From: Simon Davis
Sent: 14 September 2020 11:57
To: Kate Little <[REDACTED]>
Cc: Sam Pinkus <[REDACTED]>
Subject: RE: EV Charging - Yapton

Thanks. I have asked for the plans to be added and have also asked Env Health to comment. We use our own standards in the Parking SPD rather than those that WSCC use.

DD427L01-L02 Landscape General Arrangement Plan

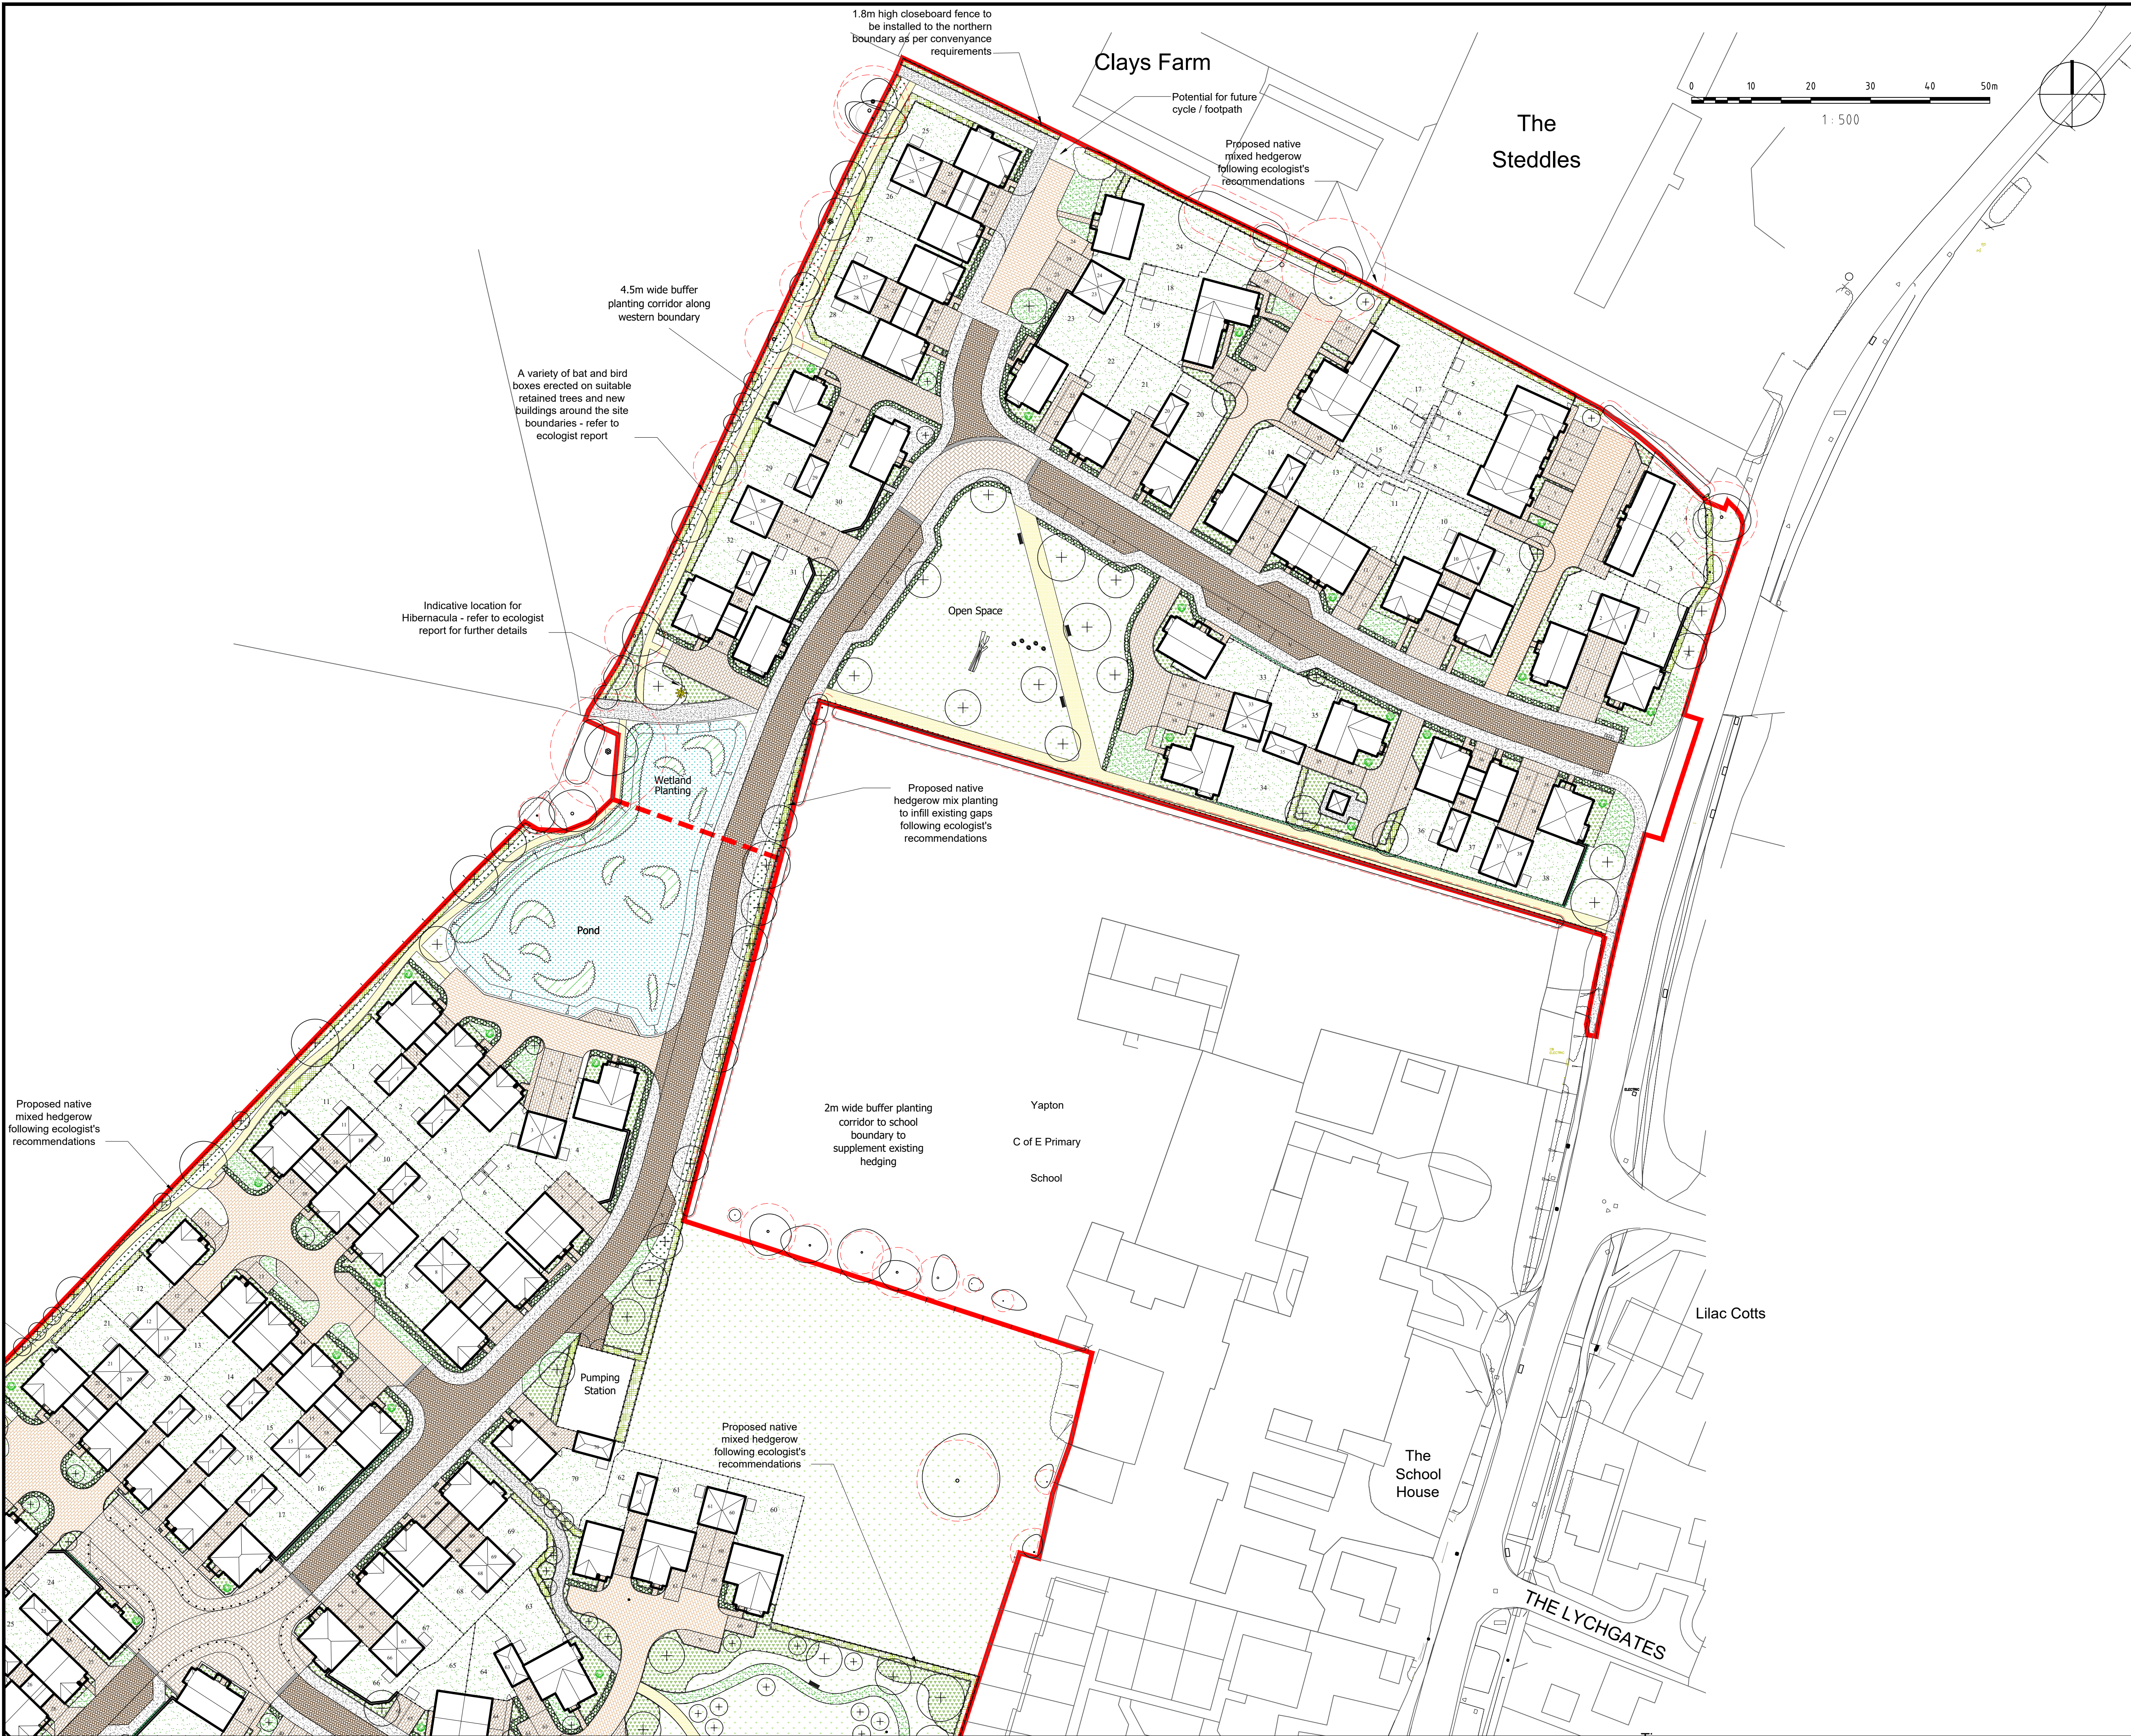
I am aware that you cannot propose works on land outside of your control. Looking at your plans, I am happiest with the connection at Stakers Farm although I think your road should not terminate at the boundary and it would be much better set in slightly with landscaping. Then you just need to ensure that the pavement/path on the northern side of the carriageway terminates at the boundary allowing access onto the private track. I would expect this path to be provided up to the boundary and finished level with the track. It should also be wide enough to allow cycle and pedestrian use.

It is not as clearly shown in the other site adjacent to Clays Farm. You have the link onto the existing PRoW which runs inside your site and out towards the NW but it is not clear where or how there will be an access into Clays Farm. This should be along the same lines as for the one at Stakers.
